Application for a non-material amendment following a grant of planning permission.

<input type="text" value="Erection of 30 bed care home and 4no extra care units (C2) with ancillary parking"/>	
Reference number:	<input type="text" value="APPLICATION NUMBER: 18/02037/FUL"/>
Date of decision	<input type="text" value="17/05/2019"/>

Amendments to increase the head heights of all windows and moving art stone band in line with this. Window transom heights also amended to avoid visual intrusion for occupants in line with Equality Act Guidance

FRONT ELEVATION

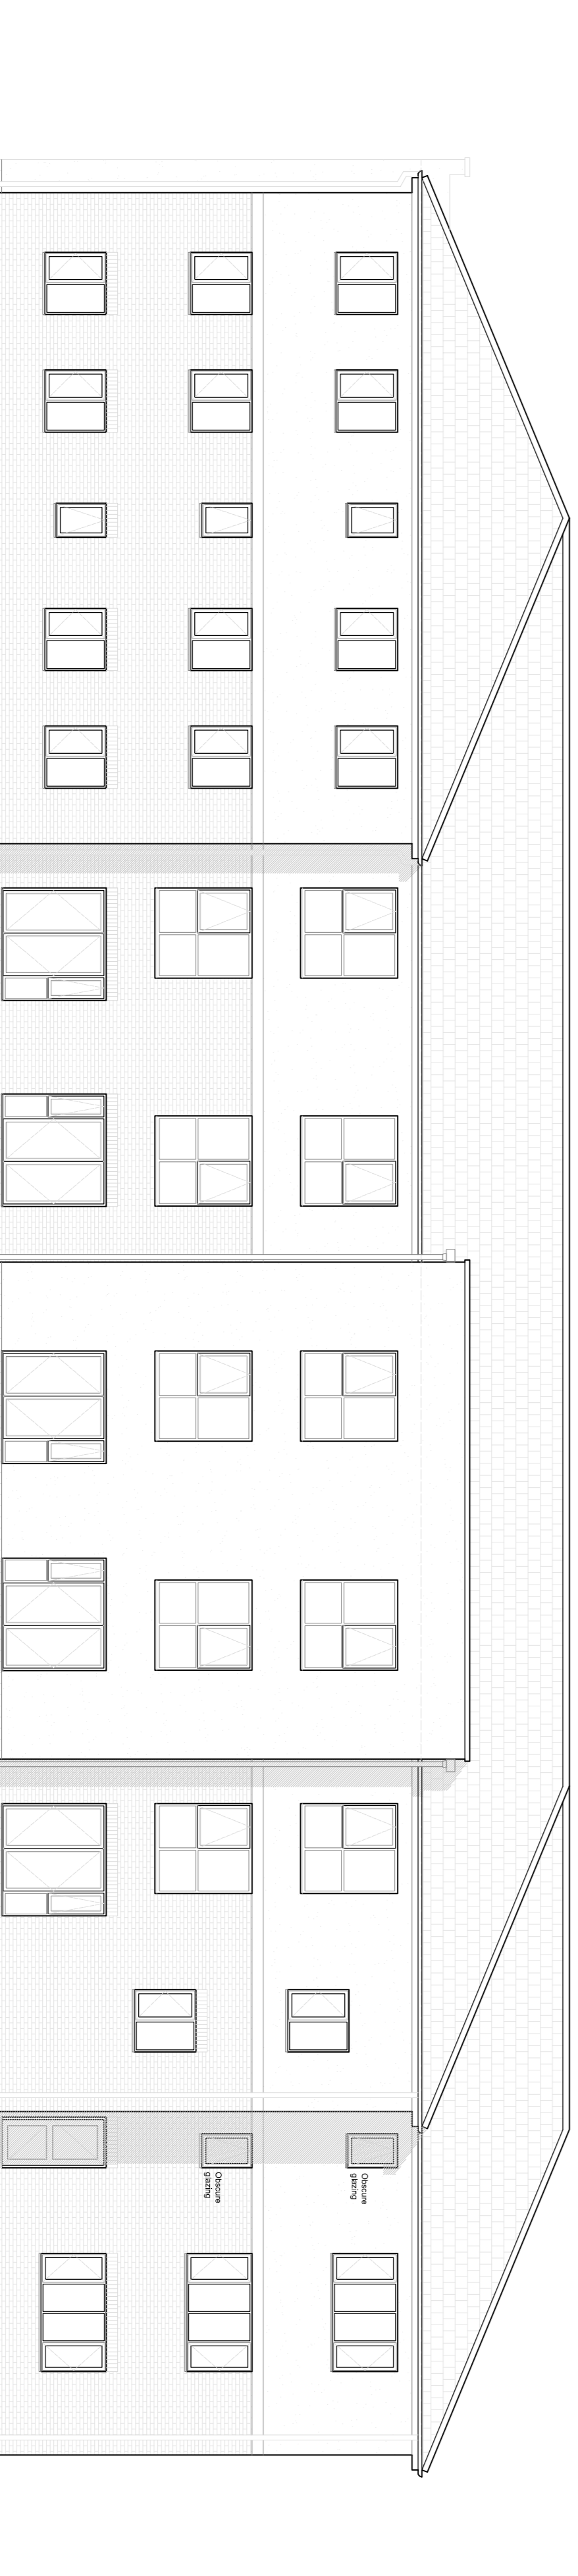
Increase levels of natural light within the building, which is beneficial for the residents. Window transom heights amended to avoid visual intrusion for occupants in line with Equality Act Guidance

S+SA_6498_SK103 A_ Proposed Elevations
